DECISION DELEGATED TO HEAD OF PLANNING

Application No: H17-0130-23 **Applicant:** Mr I Bates

Proposal: Demolition of 180 Station Road, associated outbuildings, adjacent shed and erection of 7 two and three bed houses

Location: Land Off Station Road Surfleet Spalding

DRAWN EG	PROJECT DESIGNER KB	PROJECT DIRECTOR KB
DATE 06.01.2022	SCALE 1:200 & 1:1250	PAPER SIZE A1
DRAWING NUMBER 582.SL.01

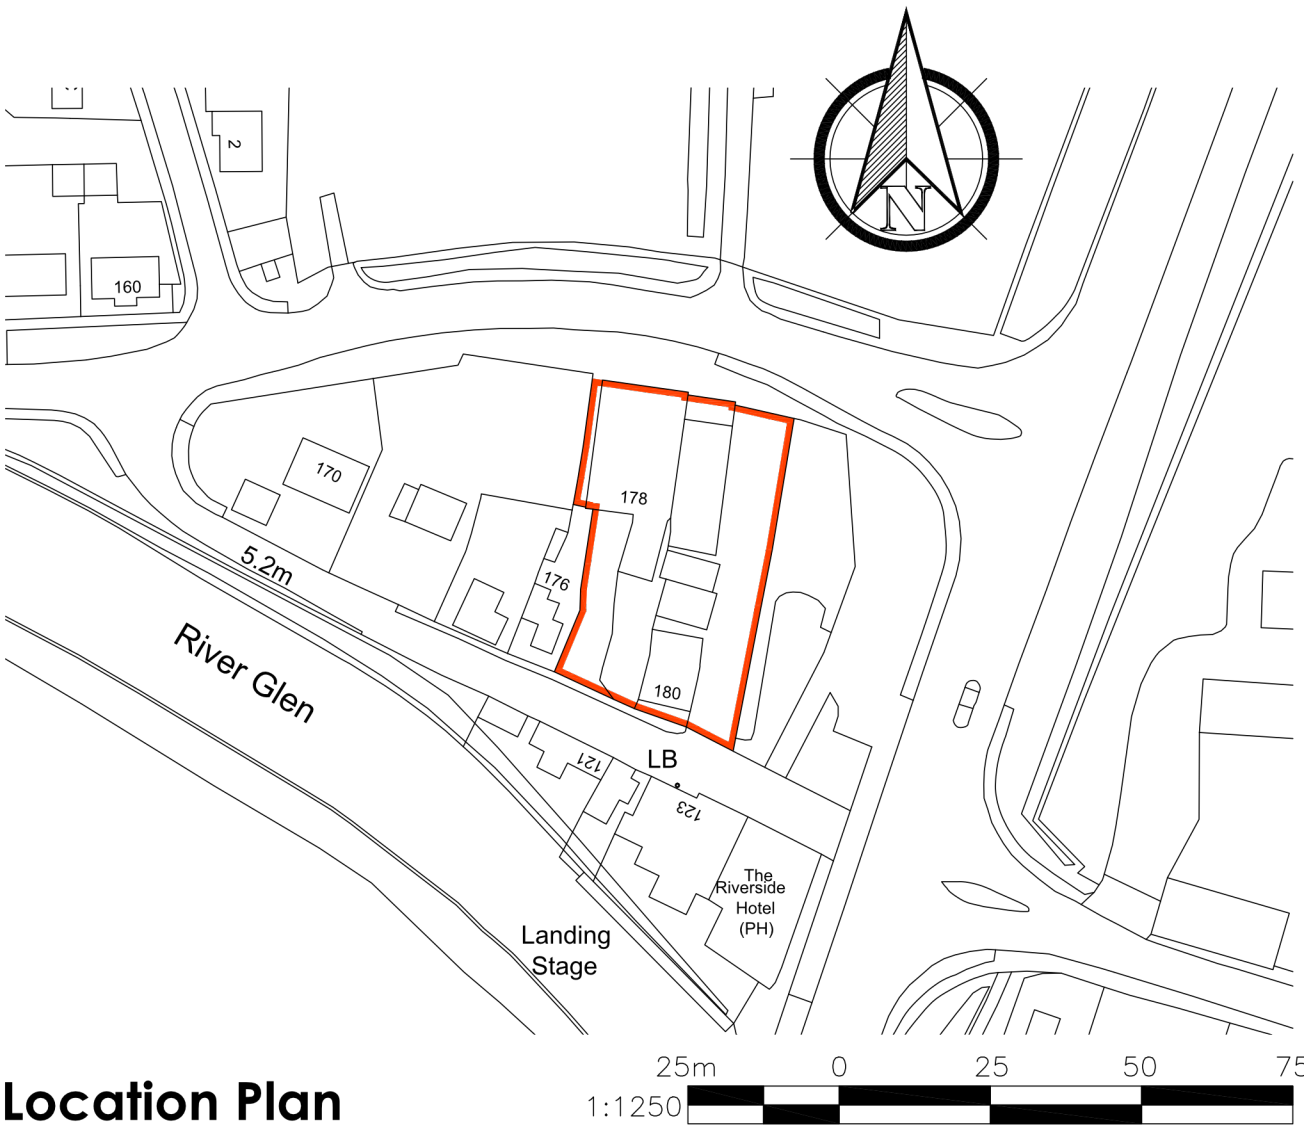
This application has been amended to provide a relocated 2 metre wide public right of way at the eastern boundary of the site and clarify the position of the public right of way.

Statement) together with other documents and having taken the advice of my colleagues, the County Council considers that there is sufficient tolerance within the legal record for this part of the public footpath to run north-south along the inside of the eastern boundary of the development site. As such, the County Council will ensure that the electronic working copy rights of way map is amended to reflect this. Despite that this part of the public footpath having been set out on this line for the past 16 years with a width of 1 metre and a stile at one end and a kissing gate at the other end, there is nothing in the legal record which has ever limited the public footpath to this width. As such, the County Council has advised the applicant that a 2-metre for the public footpath be provided within the scheme or be left, as this would ensure that there is sufficient room to allow for two pedestrians to pass each other on the route."

It is considered that the stance of the Public Right of Way Officer is acceptable. The comments given will allow the development to progress and provide an upgraded and clearly defined public right of way for further future use.

DRAWN EG	PROJECT DESIGNER KB	PROJECT DIRECTOR KB
DATE 06.01.2022	SCALE 1:200 & 1:1250	PAPER SIZE A1
DRAWING NUMBER 582.SL.01

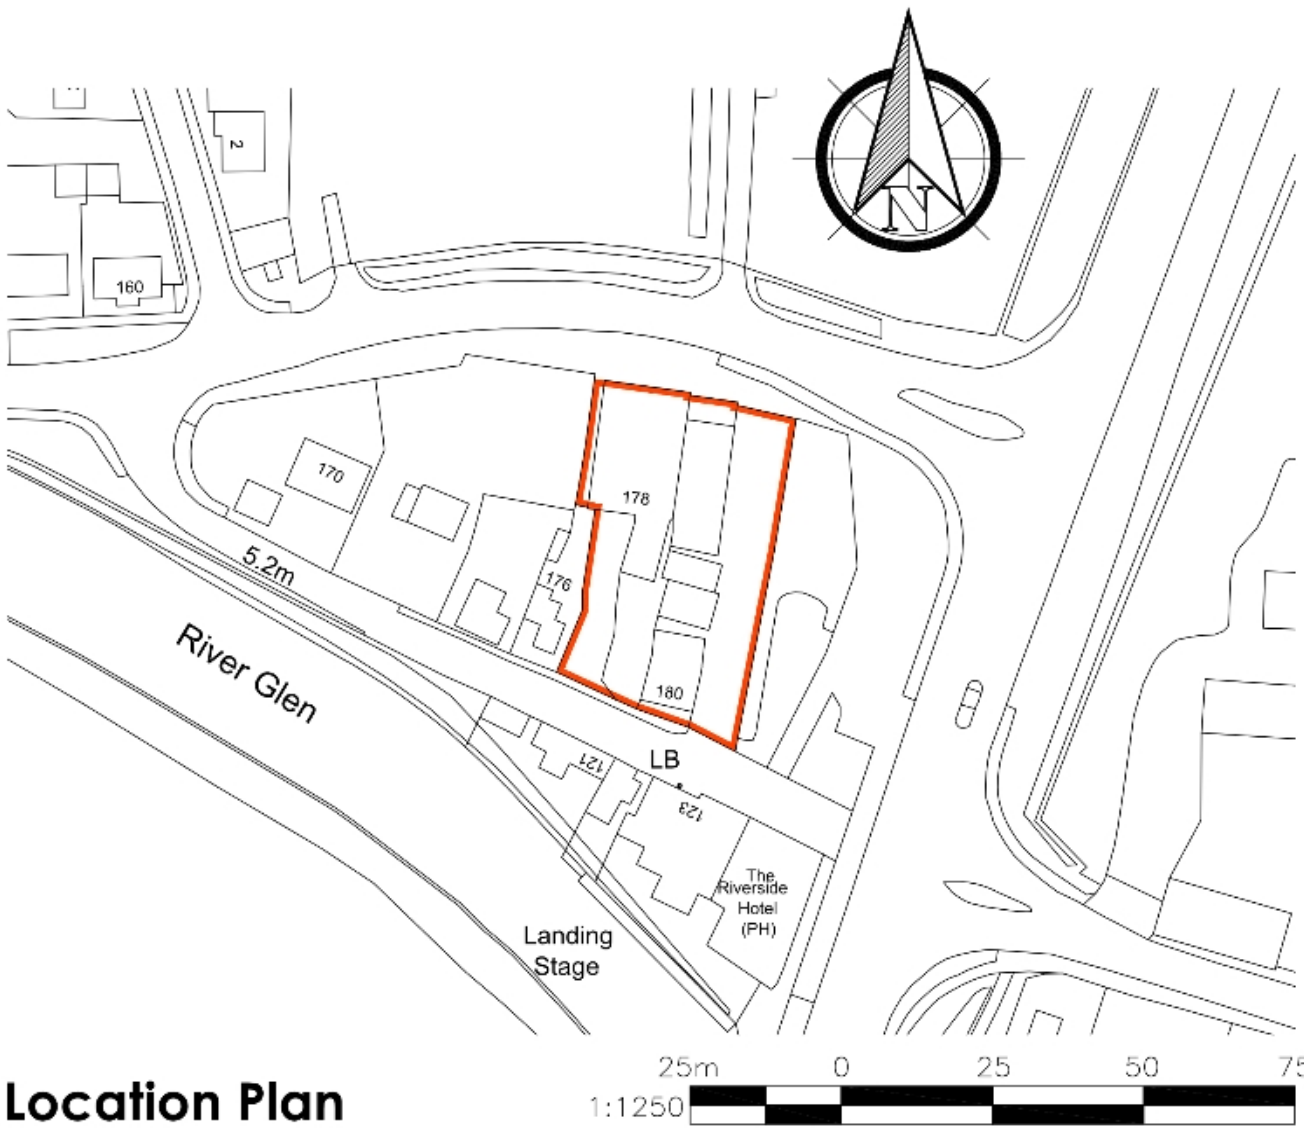
The proposed refuse and recycling strategy has been provided on the updated plan 582.SL.01 Rev B. The strategy states: "Each home is to be provided with internal refuse / recycling bins. Once the sacks from the internal bins are full they can be taken and stood in external wheelie bins provided by the developer, within the private gardens. On the day of collection the occupier will wheel the wheelie bins from the garden to the kerbside at the front of the site and remove the sack(s) from the wheelie bin and place them by the kerbside. The wheelie bin will then be wheeled back to the private garden."

Plots 4, 5, 6 and 7 are over 30 metres from the kerbside. Usually a private collection company or combined wheeled trolley is requested in this scenario. However, the preferred refuse collection strategy of the Environmental Services does not consider wheelie bins which are not used across the district. Despite repeated requests for a consultation response the Environmental Services Department have declined to respond.

It is considered by the Local Planning Authority that the proposed collection scheme allows for waste to be securely stored and safely transported. Therefore, the proposed scheme is considered appropriate for the site.
